Planning Officer: Simon Davis

Planning Application Ref: AW/71/18/HH

Location: 36 Kingsway, Aldwick

Description of works: Demolition of existing ground floor extensions to front of property, construction of a single storey rear extension and reworking of existing external hard and soft landscaping. This application affects the character and appearance of the Craigweil House Conservation Area.

Proposed Ground Floor Plan

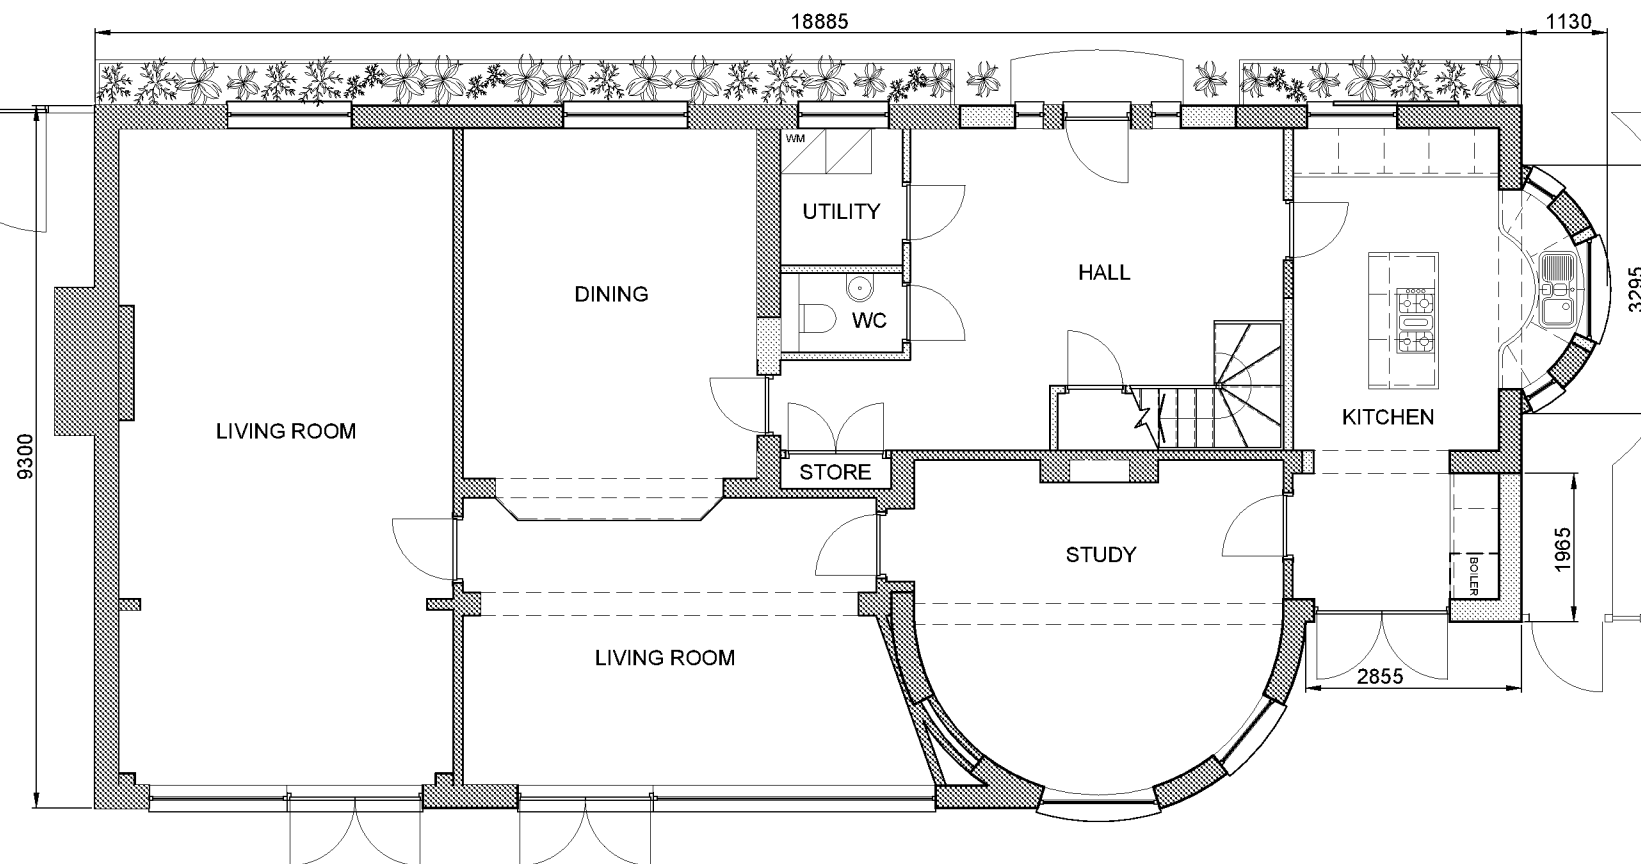
I had not initially considered the methodology/materials to be employed during the proposed construction of white rendered pillars either side of the (new) east driveway entrance.

This feature is referred to in the Design and Access Statement and best illustrated in plan drawing C0019-P215G. It is not referred to in any version of the main Arboricultural Impact Assessment document. Presumably omitted initially, as excavation was not deemed to reside within the RPA of T5.

Following revision of the RPA, as agreed between all parties – excavation to facilitate construction of the eastern pillar will occur within the new RPA. As such, there will need to be some reference to methodology and inclusion of soil/root protection measure to limit the effects on tree health.

- ***The excavation for and construction of; footings for the eastern pillar (driveway access) within the RPA of T5, will be undertaken with care so as to avoid unnecessary damage to tree roots. Only hand-digging is permitted, and of sufficient depth and width so far as is necessary. Leachate from curing concrete can be toxic to tree roots therefore all pits are to be lined with impervious membrane before pouring concrete.***

- Tree Protection Fencing - minimum extent
- Recommended Root Protection Area (RPA)
- Uniform RPA - not recommended

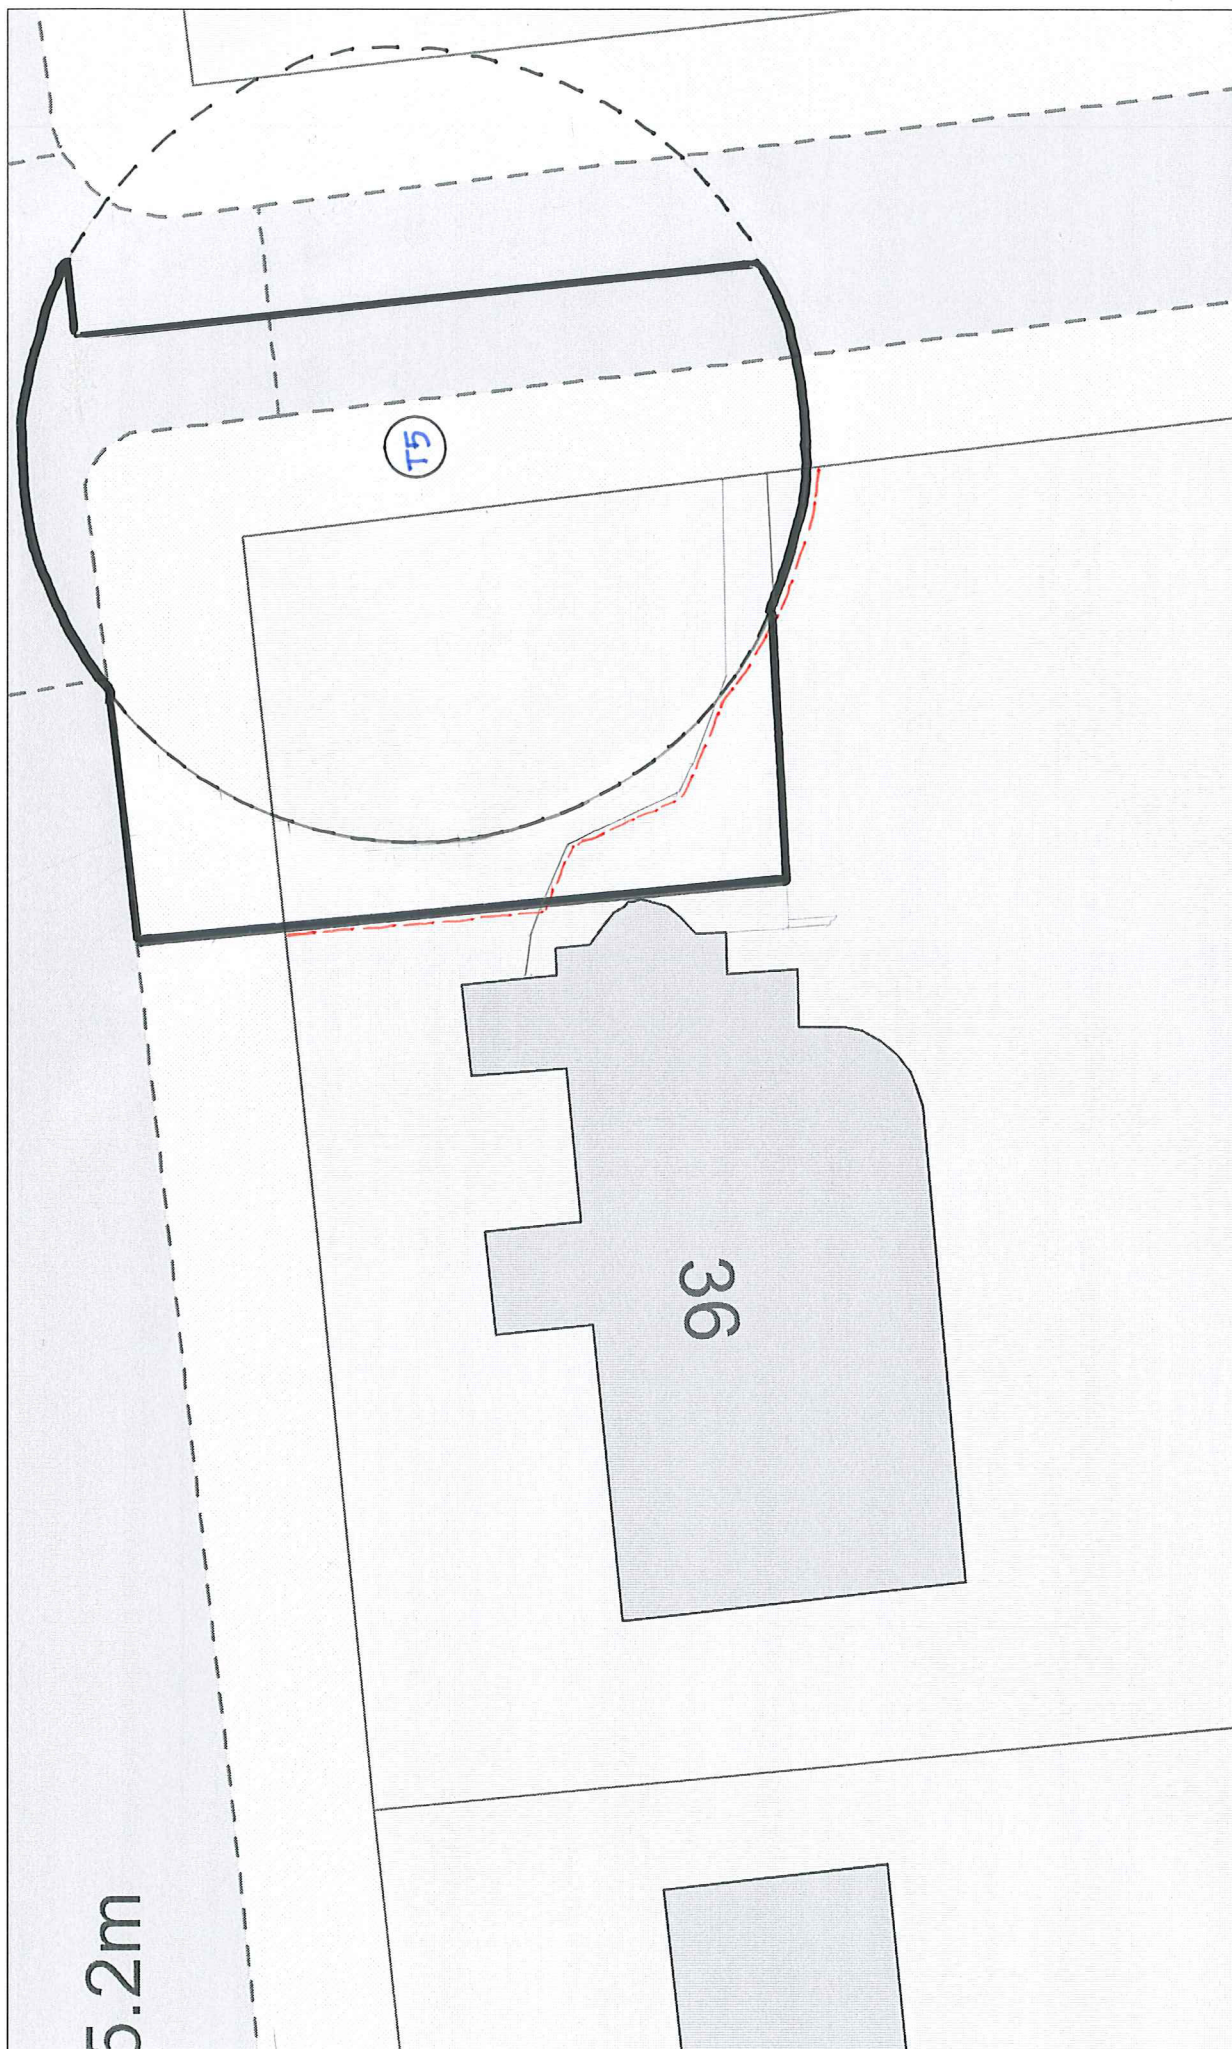
- I attach an indicative plan showing the desired RPA outcome for T5 to be adopted in a revised plan drawing, which can better inform a design. If necessary, I would be happy to meet the applicant’s agent to discuss the methodology and measurements that support this plan. Site meeting with Arboricultural Consultant, Architect and Residents held on 3rd July 2018.

Tree survey

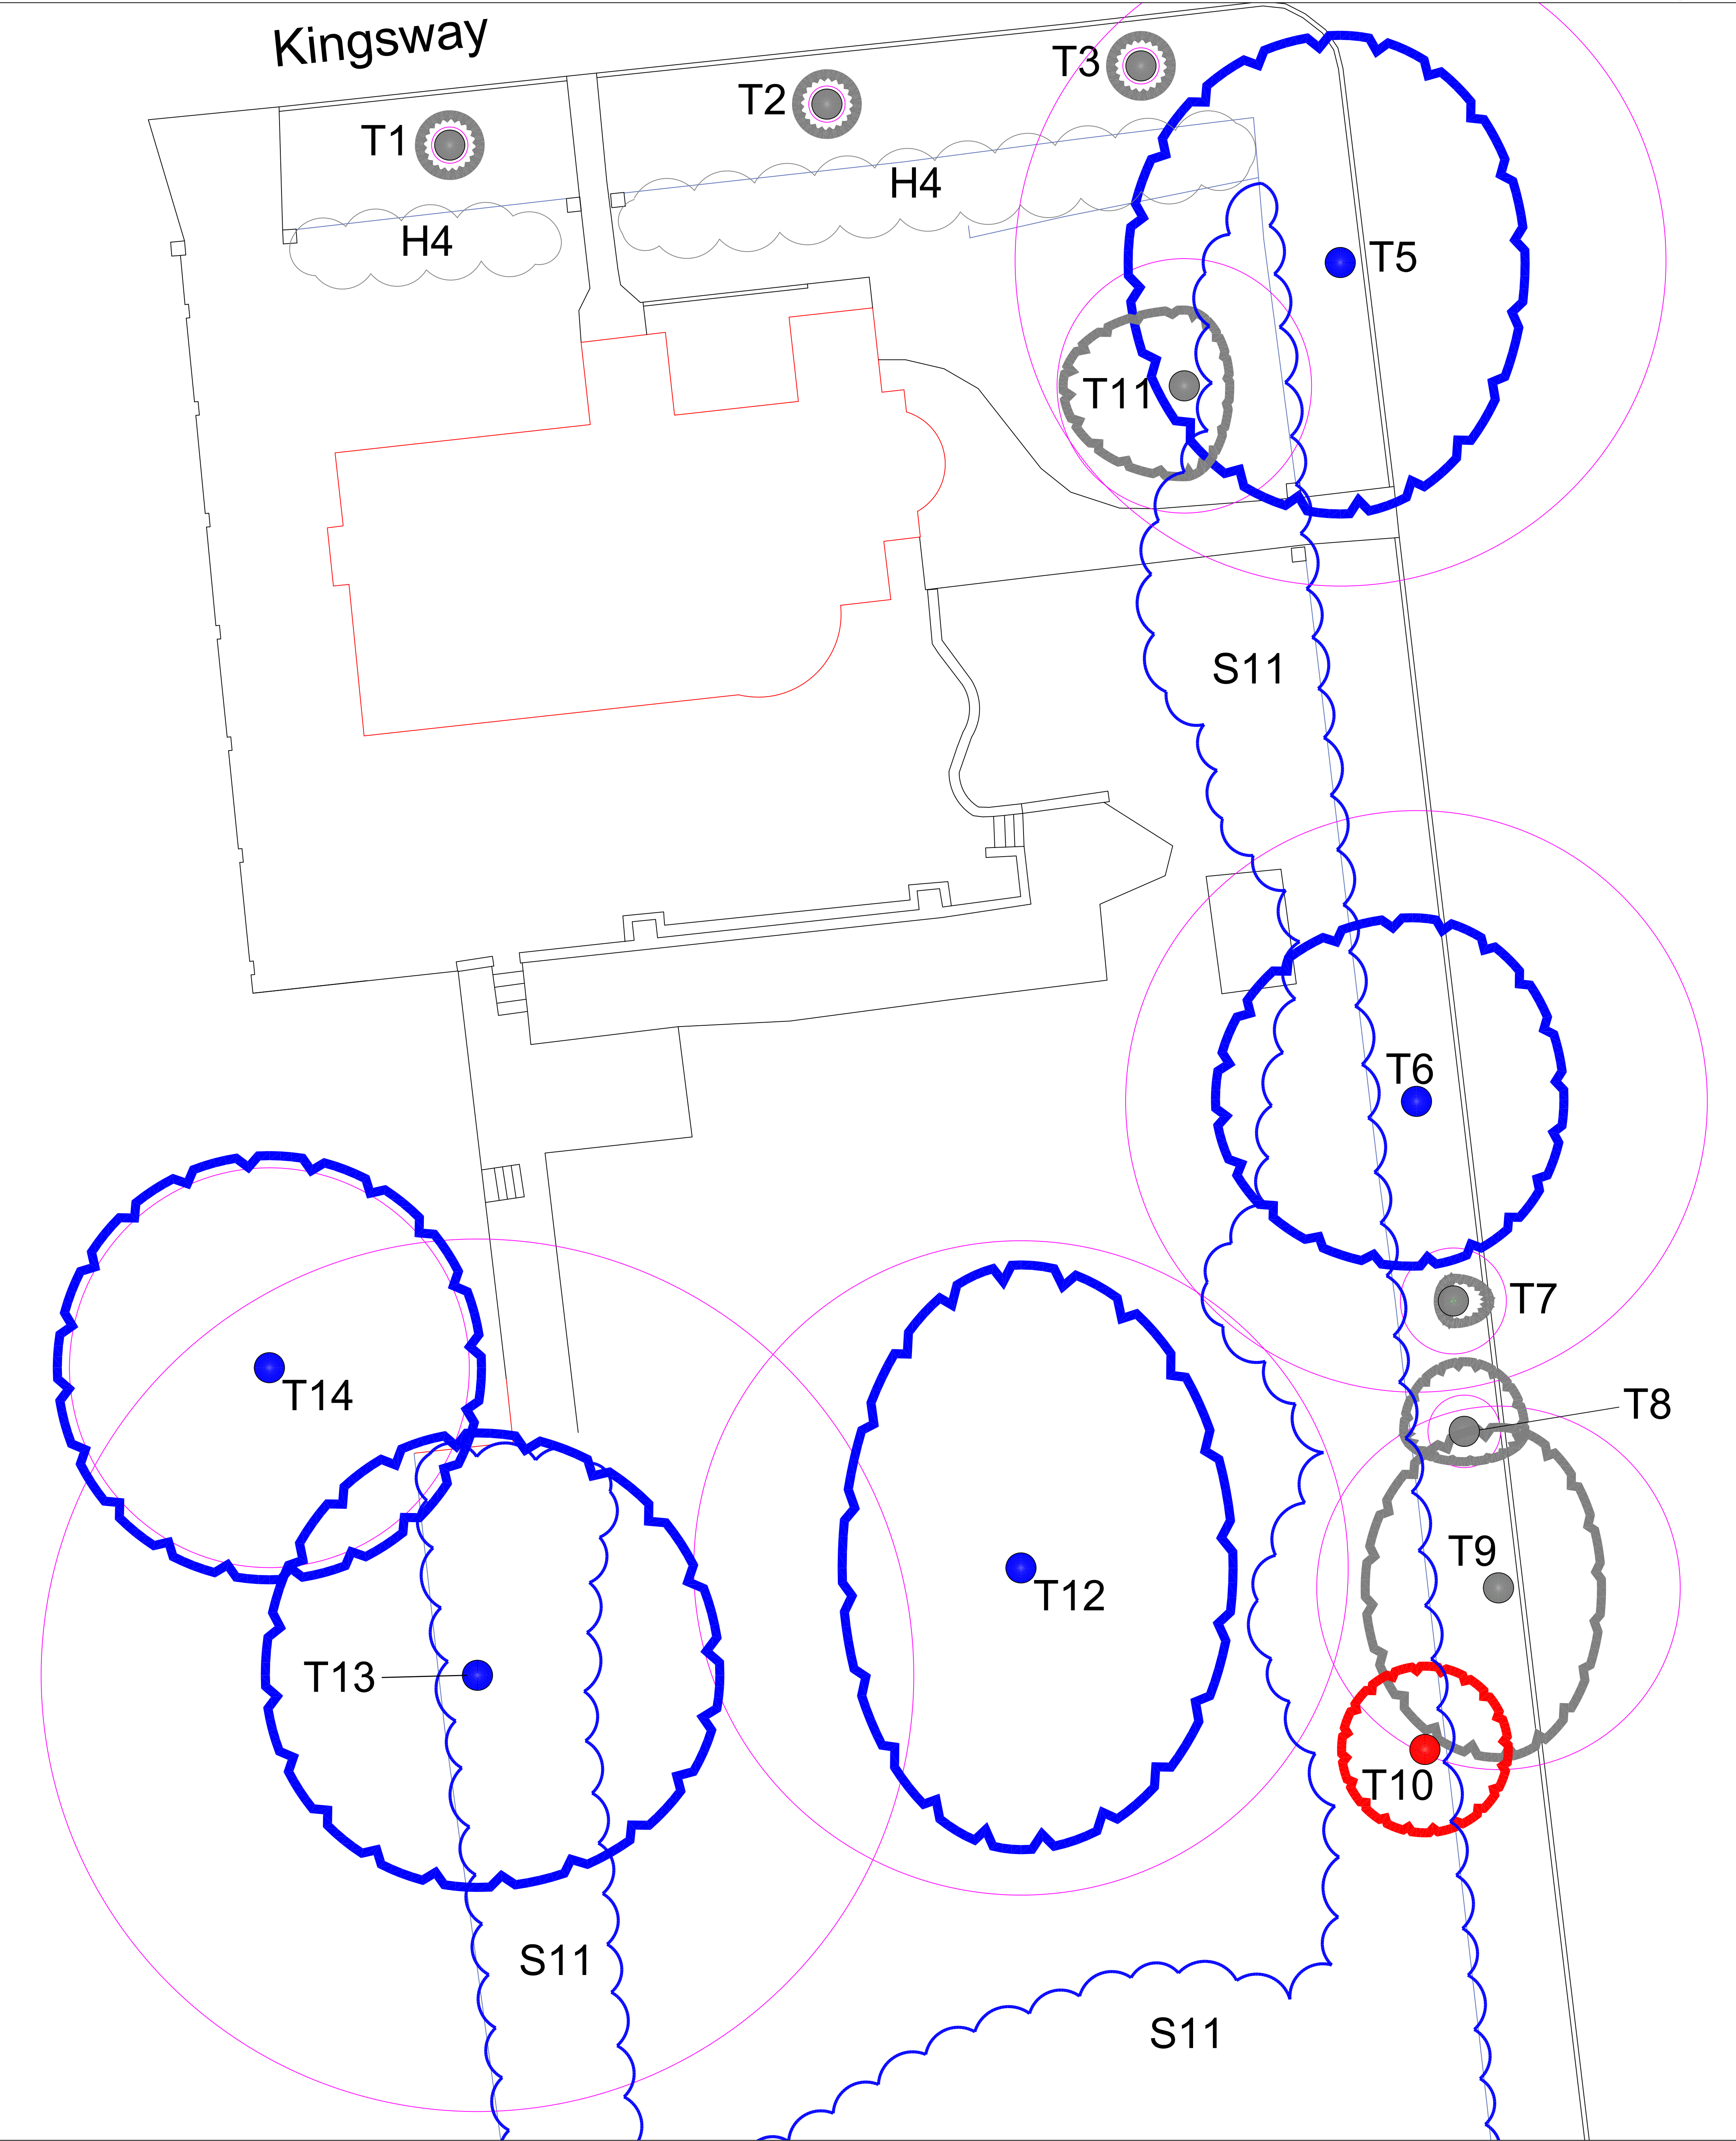
- The Tree Survey data mostly accords with the requirements of BS5837:2012 and I agree with the retention category ratings but there is a significant omission; namely the absence of Root Protection Area (RPA) measurements from the tree survey schedule or elsewhere in the AIA. This element of tree survey data is fundamental to achieve adequate tree protection.

- Of specific interest is T5 (horse chestnut), the subject of an Order (TPO/AW/5/16) and listed as T-1 on the associated Schedule. I measured its stem diameter at 1.5m height to be 895mm and not the recorded 800mm. This may seem a small matter but recognising the ideal RPA is significant in the context of this development proposal - which I return to later in more detail.

- As it stands, I must raise an **OBJECTION** to this application in its current form.
- RPA measurements (radial spread and area) must be added to the tree survey schedule to inform the process. The greater measurement of 895mm has now been recognised and informs the revised RPA (polygon). The agreed RPA broadly follows the indicative plan below but rejects the irregular element over carriageway in Kingsway and compensates with a comparable area of extension to the south – which I am able to support. The mutually agreeable RPA is detailed on the **AIA/AMS drawing no.602 – Rev B**.
